# CITY OF ALBUQUERQUE

**Re: Cunado Retail Center Drainage Amendment**  
**Engineer's Stamp dated 8-28-08 (C18/D76)**

## Regarding: Cunado Retail Center Proposed Drainage Amendment

- [24] INSTALL STOP SIGN AS PER MUTCD, R1-1
- [25] 12" SIDEWALK CULVERT PER C.O.A. STD. DWG. # 2236. 8" SIDEWALK CULVERTS INSTALLED
- [26] CONTRACTOR RESPONSIBLE FOR FIELD LOCATING EXISTING 36" CMP AND INSTALLING A CONCRETE PLUG AT INLET OPENING.

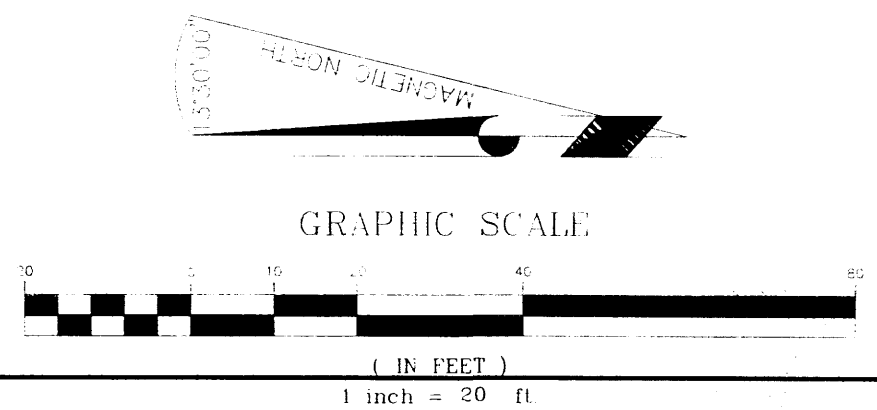
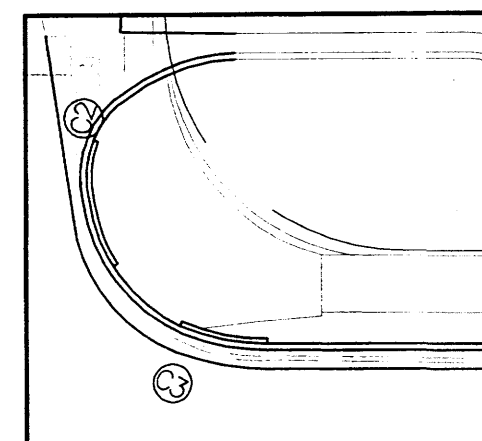
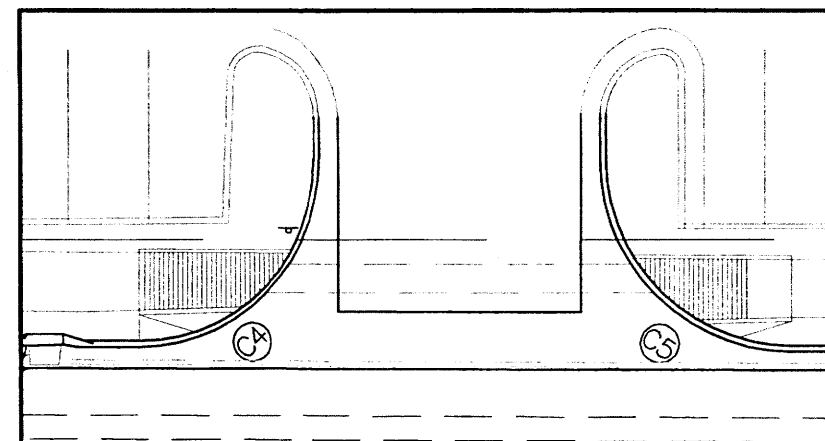
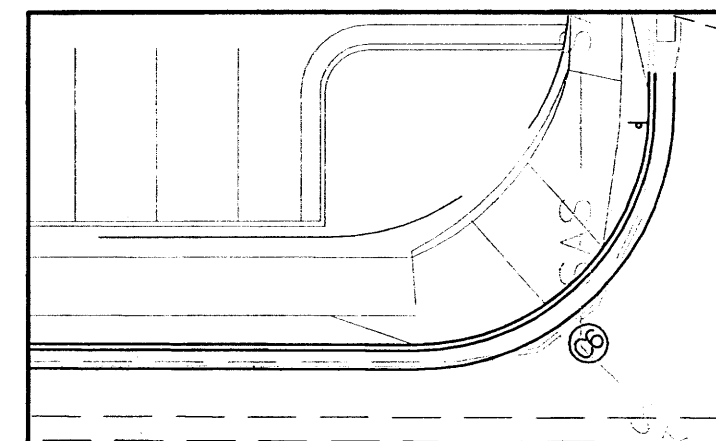
The San Mateo Blvd. Improvements Project for the Cunado Retail Center has been completed. However, the construction contractor made an error by installing 8-inch wide sidewalk culverts instead of the 12-inch wide sidewalk culverts as designed and shown on Sheet 5/7, Note # 25 (attached).

The attached calculation sheet shows that the two 8-inch wide sidewalk culverts will provide for 2.91 CFS of drainage capacity from the parking lot area. The approved site drainage calculations show that 2.36 CFS is required in order to meet peak flow demand. We therefore request that you accept this proposed drainage amendment rather than require that the drainage culverts be removed and reconstructed as originally approved.

Based upon the information provided in your submittal dated 8-26-07, the above referenced plan is approved as amended. I have provided pictures of what was actually built and determined that although they neither match the original plans or the calculations provided, the 4" pipe outlet in the private curb will effectively reduce the inflow to the culverts and should not overtax the capacity of them. In the future, please certify the actual as-built conditions.
